TECHNICAL NOTE

Job Name: North Littlehampton

Note No: TN004

Subject: Response to Environment Agency Objection dated 24th January 2022

2D Node Points from 2010 Infoworks Model Centered on **Black Ditch North of Littlehampton** -
Created **11/04/2016** [Ref: SSD/7430]

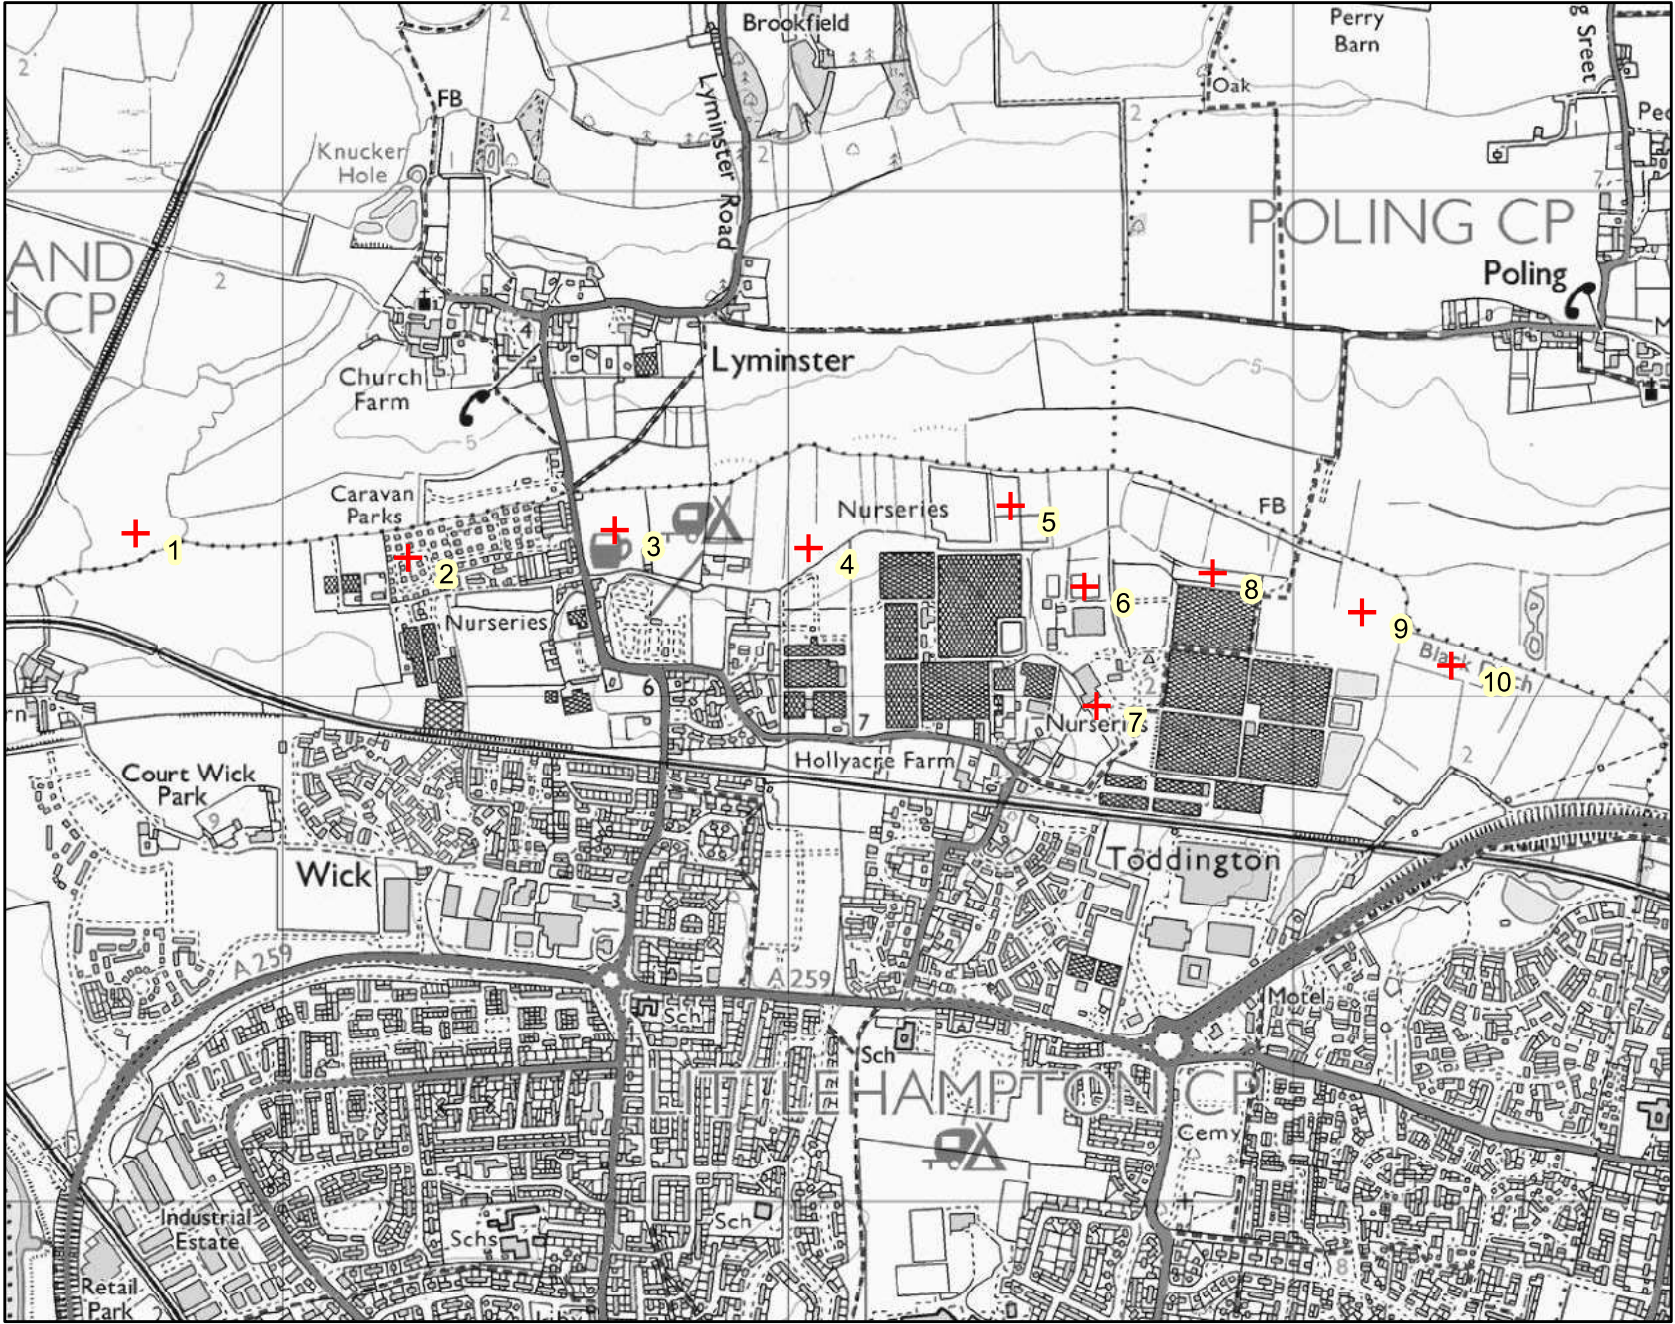
The defended 0.1% AEP flood level has been used to calculate flood plain compensation, instead of the undefended level, which is best practice; especially considering the modelling used is over 10 years old and no additional modelling has been undertaken to establish the impacts of climate change. We would therefore request to use the undefended 0.1% AEP flood level of 2.90m AOD for the flood plain compensation calculations.

Based on this proposed defended 1 in 1000 year flood level of 2.38mAOD is deemed to be agreed with the EA (as per the 2017 liaison) as an appropriate flood level to assess the flood compensation scheme.

In summary, the defended 1 in 1000 year flood level of 2.38mAOD is the agreed design flood level to use in the flood compensation analysis.

FLOOD COMPENSATION

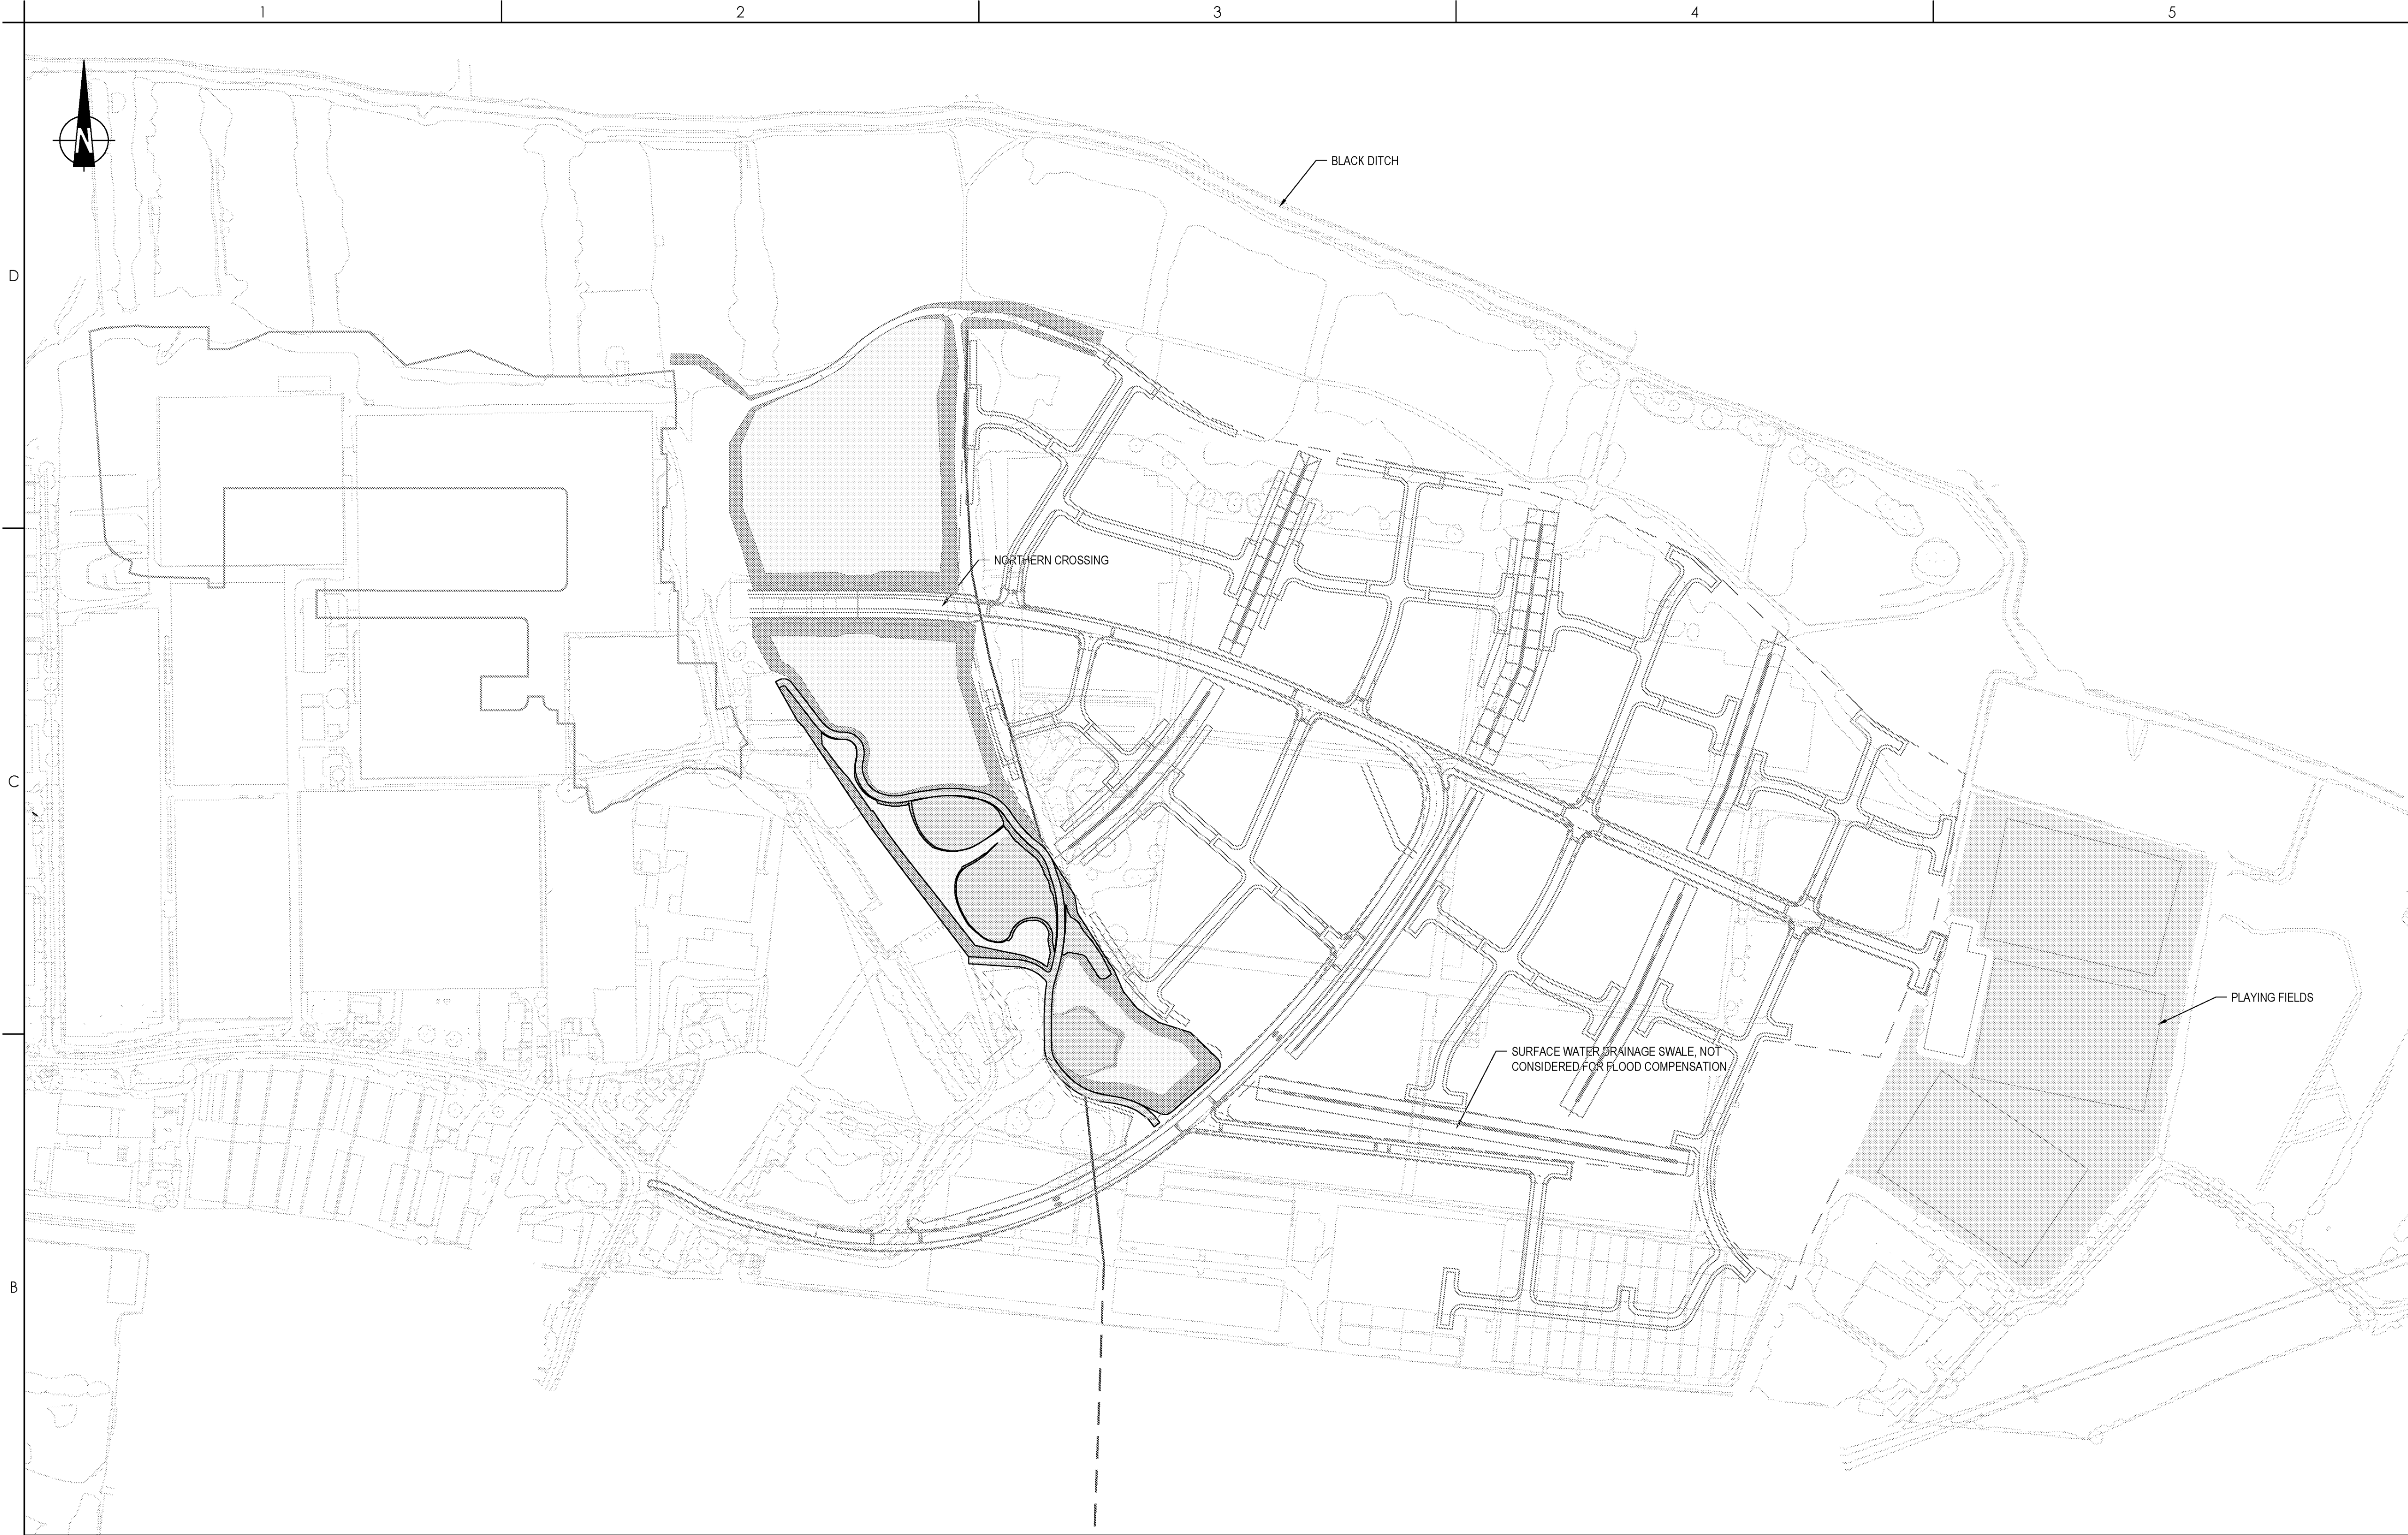
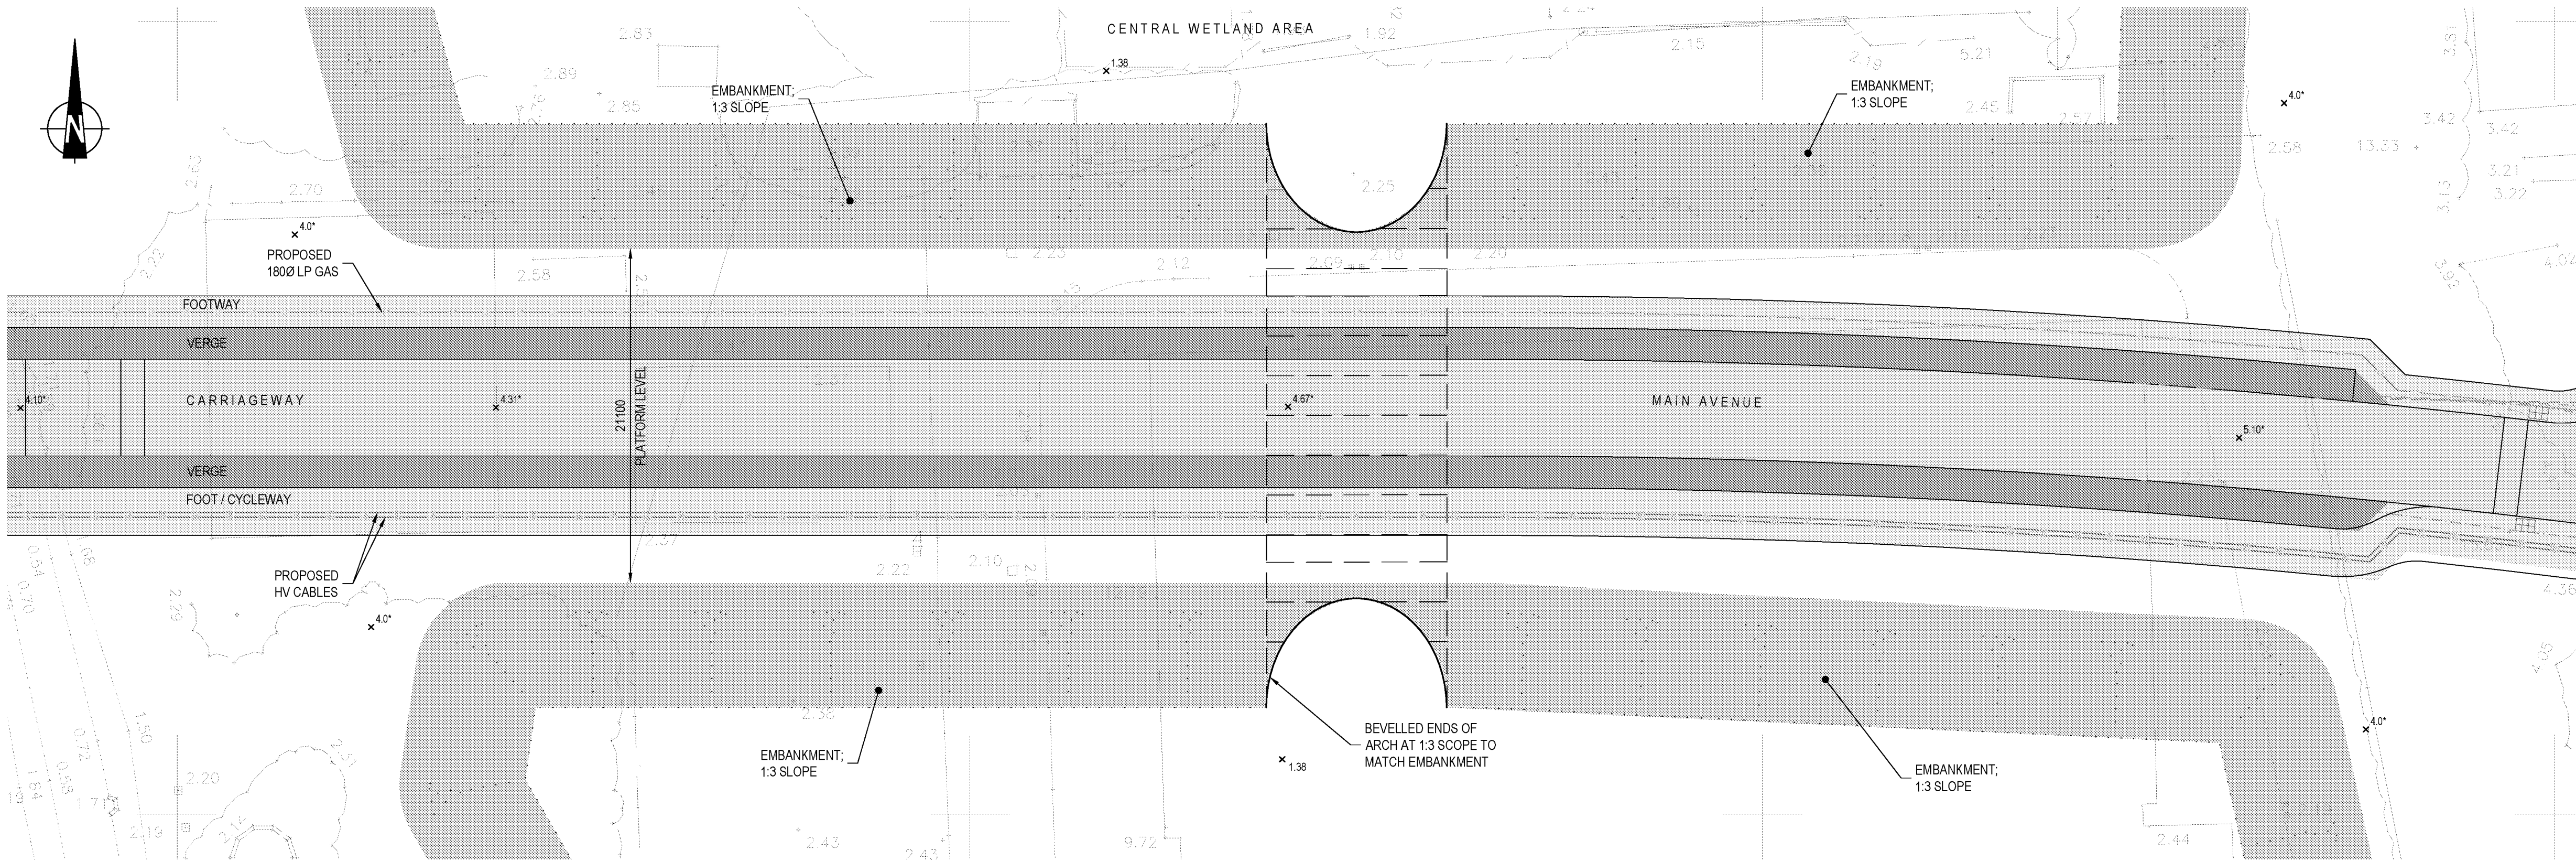
The flood plain compensation proposed with this planning application will only create 324m³ additional storage, which is considerably lower than the 27,300m³ proposed at the outline planning application, which was one of the reasons of the removal of the Environment Agency (EA) initial objection.

The calculations provided in table 1 of the Technical Note show loss of storage at the lower and higher levels. To be an acceptable compensation scheme, the volume of flood gained in each particular slice should be greater than the volume lost for that same slice.

The recent review of the latest proposals has allowed the refinement of the analysis to include the final CWA form, including the free-flowing low-level drainage ditches. This analysis also identified that there were minor corrections to be made to the triangulation of the ground model. The result of this has now been included in the table below as well as on our revised drawing 39878/4001/008 Rev. D and identifies modifications at all bands.

As a result of the update, the current design shows significant overall gains in storage of 8193m³ across the site, which is closer to the original FRA figure.

Following the review of the ground model and proposals outlined in our response to point 2 above, the level-for-level losses at the low levels have been updated. With regards to the principal concern at the lower levels, the revised analysis shows gains in the lowest bands with a small loss within a single band. Table 2 below shows the cumulative flood storage for all bands as a result of the flood compensation, demonstrating positive storage throughout.
